Engineers Comments Regarding Surface Water Drainage

Application Reference:	BN/42/26/HH	Reviewer Reference:	ADC/KW/PC
Planning Officer:	Jonny Cooper	Date of Review:	01/07/2026
Site Name:	5 Tattersalls Road, Fontwell, BN18 0ZA		
Application Description:	Single storey rear extension.		
Assessment Number:	1 of 1

PL- Consultation- Engineers response

Proposed Ground Floor Plan
Scale: 1:100

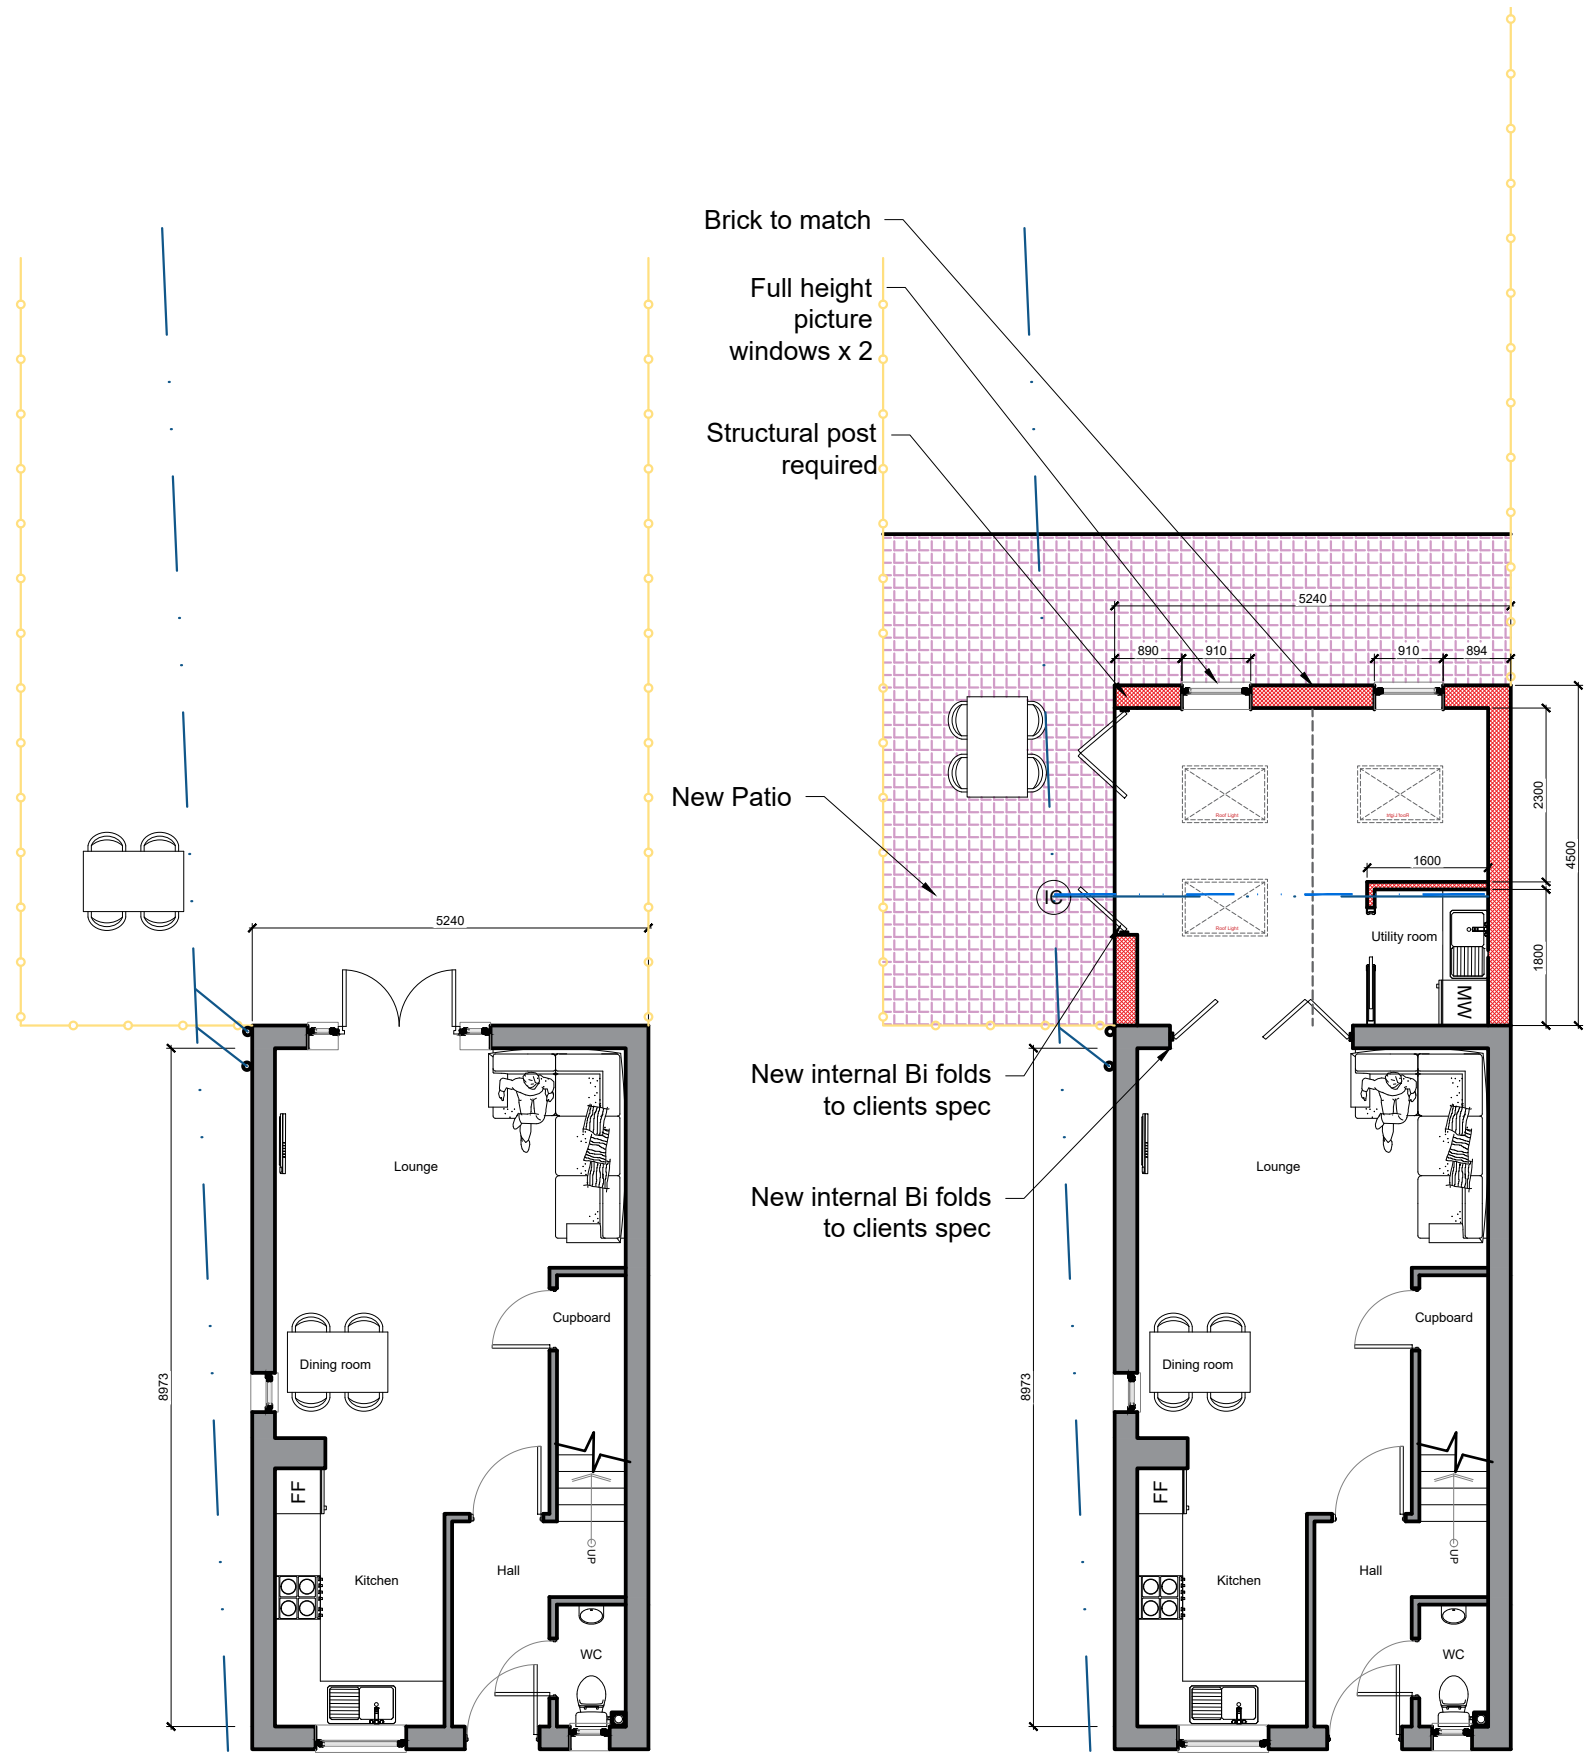
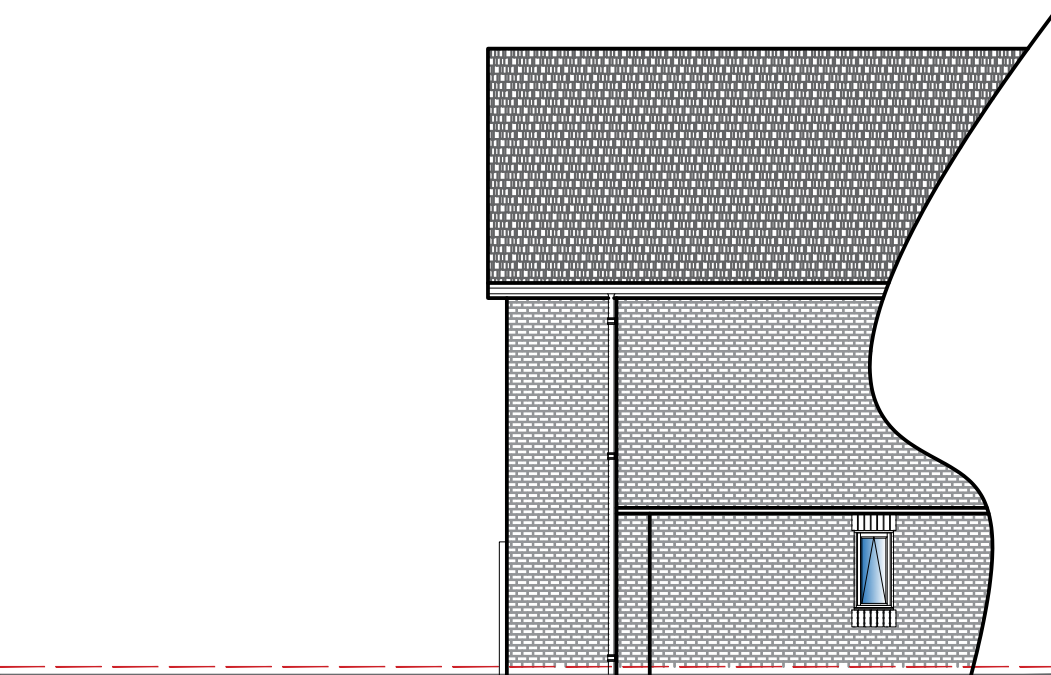
- 1.5. The applicant must ensure that the proposed extension/patio does not cause detriment to any pipework/manhole access associated with the surface water drainage system serving the existing development.

3.3. Details and calculations have been provided to evidence storage within the permeable paving to the rear of the property. However, without having proven that infiltration on-site is viable, this remains indicative of a potential proposal. Please note, as infiltration remains unproven, a detailed check of the submitted calculations has not been undertaken at this time. In the absence firm evidence, we cannot assess if flood risk will be increased by the surface water drainage of the proposed development. Therefore, this application does not accord with the NPPF as set out above and we **object** to the proposal.
